PROJECT TITLE
MALLARD PASS SOLAR FARM

DRAWING TITLE
Figure 4.3: Concept Masterplan

Viewpoints

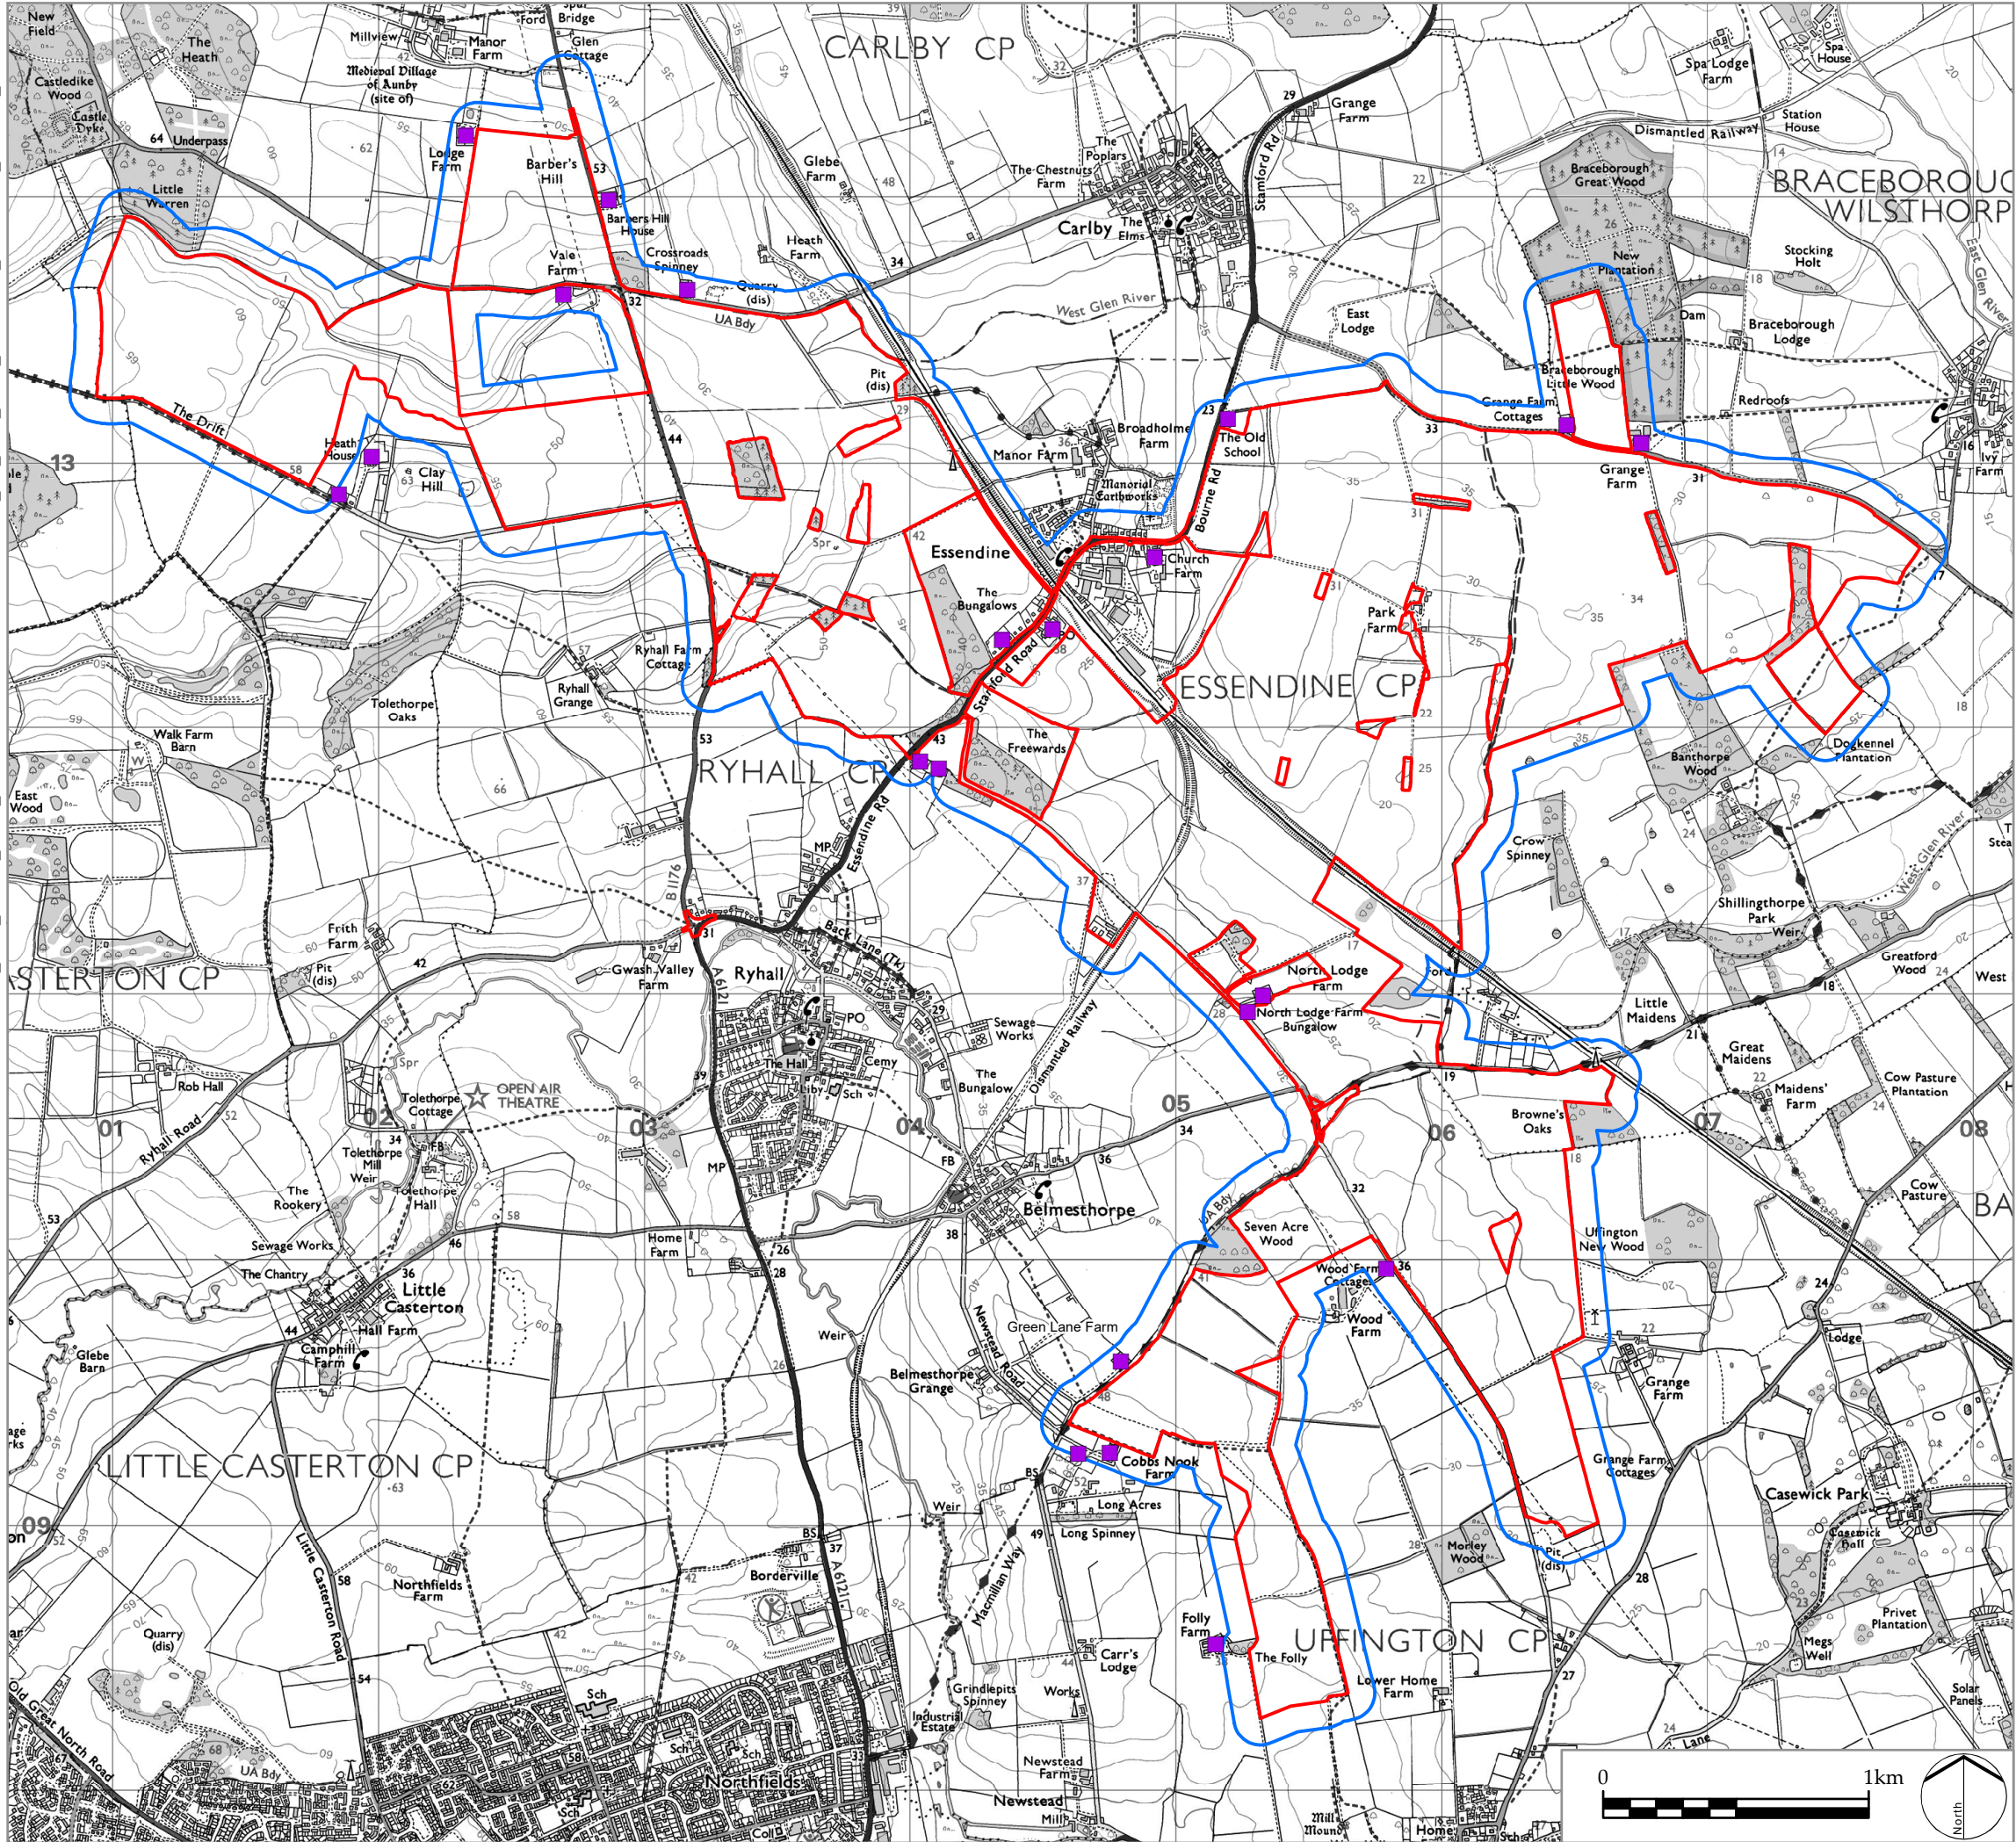
MPSF Receptor	Description	Sensitivity	MPAG traffic light system (Red - High impact, Amber- medium impact, Green - low impact)
1	The Cottage, The Drift	Close to VP 13, 2 storey cottage (Tew)	High	Will see F2/6/9 every time leave house and F3 if walk down the Drift
2	Heath House The Drift	house, mature vegetation	High	Will see F2/6/9 every time leave house and F3 if walk down the Drift
3	Lodge Farm	2 storey farmhouse + outbuilding - holiday let business	High	Views south to F4. Access tracks and compound very visible, planting needed on West boundary
4	Vale Farm	2 storey farmhouse very close to B1176 crossroads	High	Just some of F4 looking North and F5/6/9 every time turn right onto B1176. Close to crossroads with huge impact there
5	Barbers Hill House (Helen)	2 storey house, elevated location	High	Can see south/east downhill to F5, 6, 8 etc due to topography. F4 west highly visible 185m away with current hedgerow. Compound in v close proximity. From upper floors no mitigation will be sufficient. Also see F2

6	Crossroads Spinney	Fairground residents behind	High	Agree with MPSF
7	The Bungalows, A6121	3 bungalows, 2 storey building	High	With topography will be able to see F18 & 19 solar, new sub station very visible. Screening will be ineffective + noise issues
8	Glen Crescent	13 properties off A6121, 4 face south,	High	As above topography will not provide adequate screening + noise issues for houses facing S and E
9	Church Farm, Essendine A6121	Farmstead, outbuildings, vineyard, marquee hire business	High	Rising topography to old railway line. Setback in F27 above Church Farm land. Visually not affected, but badly affected by CA rights, water run-off risk to vineyard
10	The Old School House, Bourne Rd A6121	2 2 storey houses adjacent to F28	High	Rising topography to old railway line. Setback in F27 & 29 above. No visual or other effects
11	Grange Farm Cottages	2 2 storey cottages on Carlby Rd looking south across F36	High	Open view across F36 and beyond, 270m setback. Can see across to F49 & 50, 18/19, and west across B1176 on clear day.

12	Grange Farm, Carlby Road	Farm - landowner in the scheme	High	Huge F36 in front of cottages, long distance views not possible to effectively screen. Huge impact on recreational amenity
13	North Lodge Farm, Uffington Lane	Bungalow, mature vegetation	High	Filtered views to F25. Topography may allow N/NE views across railway line. Huge impact from construction.
14	Wood Farm Cottages	Views E to F49 & 50, and N to F48	High	Views East to F49 & 50, and North to F48
15	Green Lane Farm, Newstead Rd	Adjacent to F45	High	Close to F45
16	Cobbs Nook Farm, Newstead lane	Close to end of Macmillan Way	High	Adjacent to F45 next to PRow, max distance 180m away
17	Newstead hall, Newstead lane		High	Close to field 45.
18	Folly Farm, Essendine Road, Newstead	Fields adjacent to plot all shown as mitigation on MPSF	High	Close to fields 43 & 44. No solar panels visible but adjacent to mitigation area which looks south to Burghley Park.

Not in MPSF assessment - added by MPAG as feel 100m distance outside order limits is too restrictive				
	MPAG suggested receptor	Description	Sensitivity	MPAG traffic light system (Red - High impact, Amber- medium impact, Green - low impact)
19	Grange Farm +3, 2 access points off Greatford Rd & Uffington lane	Outskirts of Uffington, long farm track	High	Close to F50 and beyond to 49
20	Heath Farm PE9 4NE,	River, nr property 6 off Carlby High St,	High	Looks south to F5, 6 & 8
21	Ryhall Farm Cottage,	Landowner family, 52.699122, -0.476837 off B1176	High	Looks across to F14, 12 & 2
22	Grange Farm,	Landowner family, 52.697670, -0.479913, off B1176	High	Looks across to F14, 12 & 2
23	Housing estate rear Essendine		High	Solar visible across railway to F16 & 11
24	Tar Cottage, The Drift	Next to The Cottage and Heath House on the Drift	High	Will see F2/6/9 every time leave house and F3 if walk down the Drift

25	Barbers Hill Cottage	Next to Barber's Hill House	High	Next to Barbers Hill House, will see some views south towards Essendine and along B1176
25	Barbers Hill Farm		High	
25	The little Barn		High	
26	Manor Farm Lane residents	Top of Essendine down farm lane looking E to Greatford	High	Look across to F29 & 30 looking E towards Greatford. Birds Eye view
27	Pelham Lodge & Long Acre +	Close to Cobbs Nook Farm	High	Looks across North to field 45
28	Banthorpe Lodges	Heritage asset	High	Looks up to F53, elevated position can see through tree line from house
29	Red Roofs	Next to Grange Farm off Carlby	High	Looks diagonally across into F36. Some screening from avenue of trees
